CONSTRUCTION PLANS for JACKSON RANCH FILING NO. 4

JACKSON RANCH
FILING NO. 4
COVER SHEET

JACKSON RANCH COURT
FROM STA 16+75.71
TO STA 25+11.85
JACKSON RANCH FILING NO. 4

Markup Summary

CONSTRUCTION PLANS for JACKSON RANCH FILING NO. 4

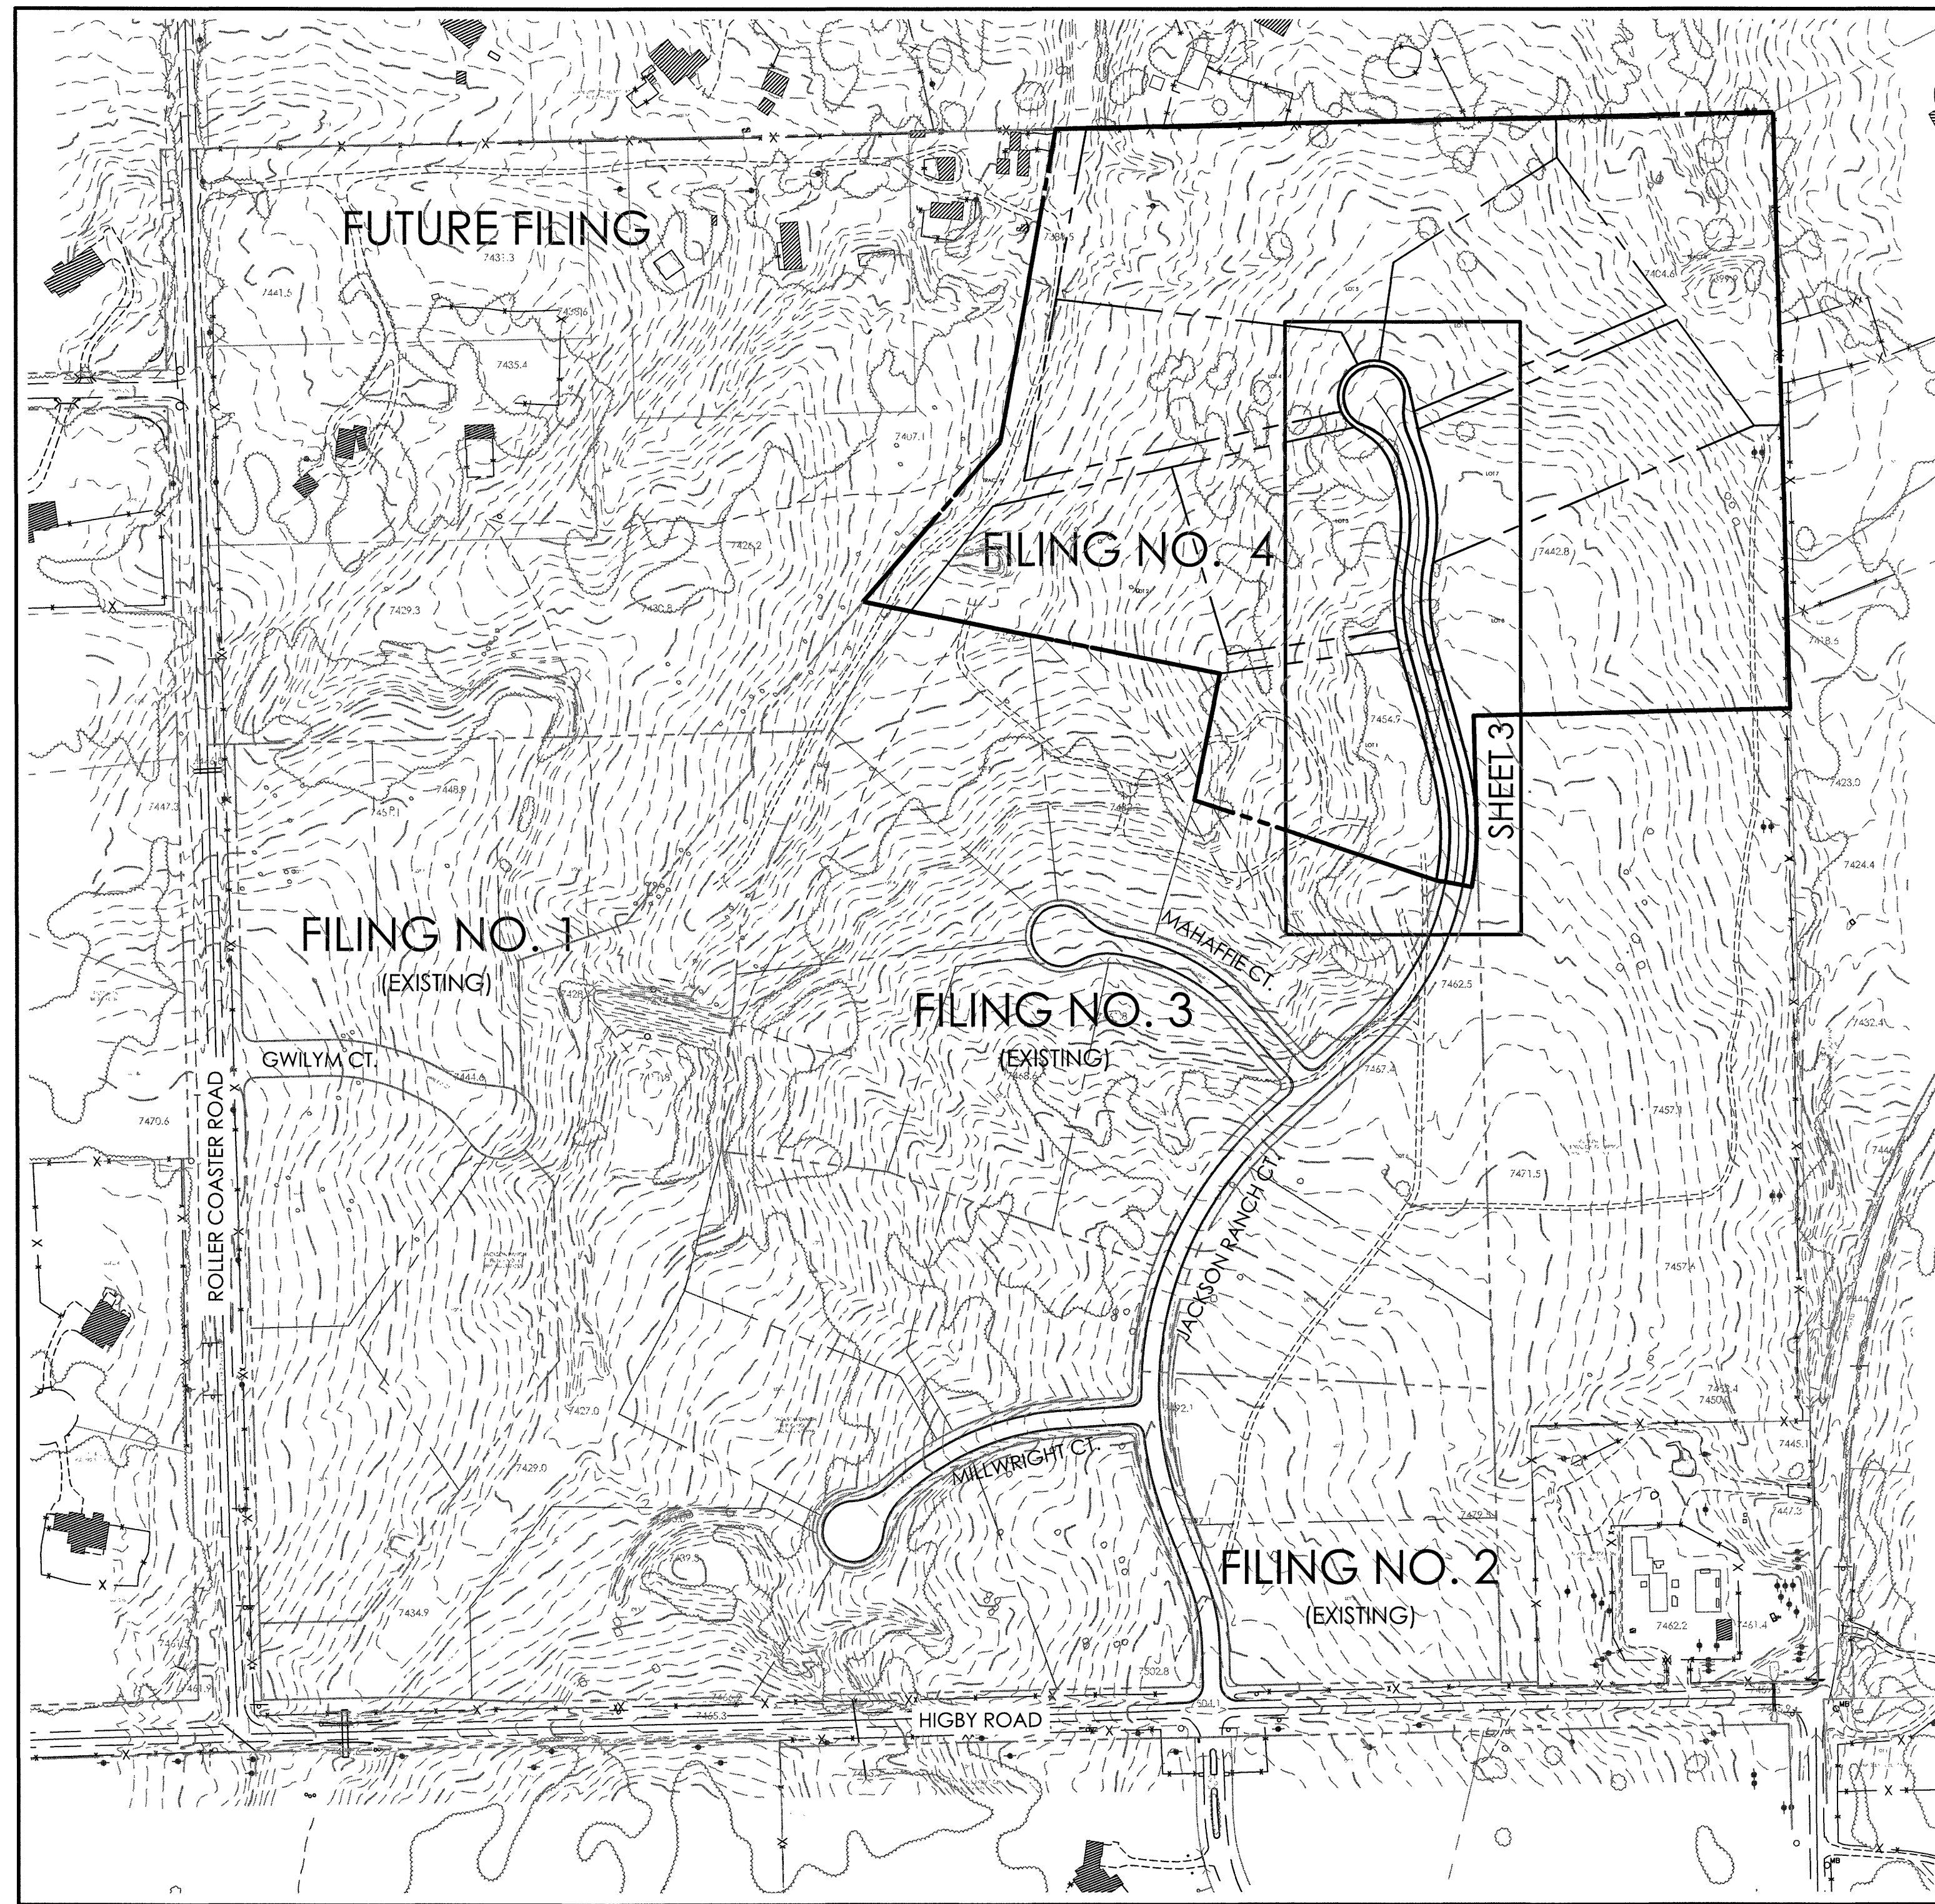
Add EPC Planning & Community Development Department.

Add "PCD Project No. SF-17-016"

Fix so street name is visible.
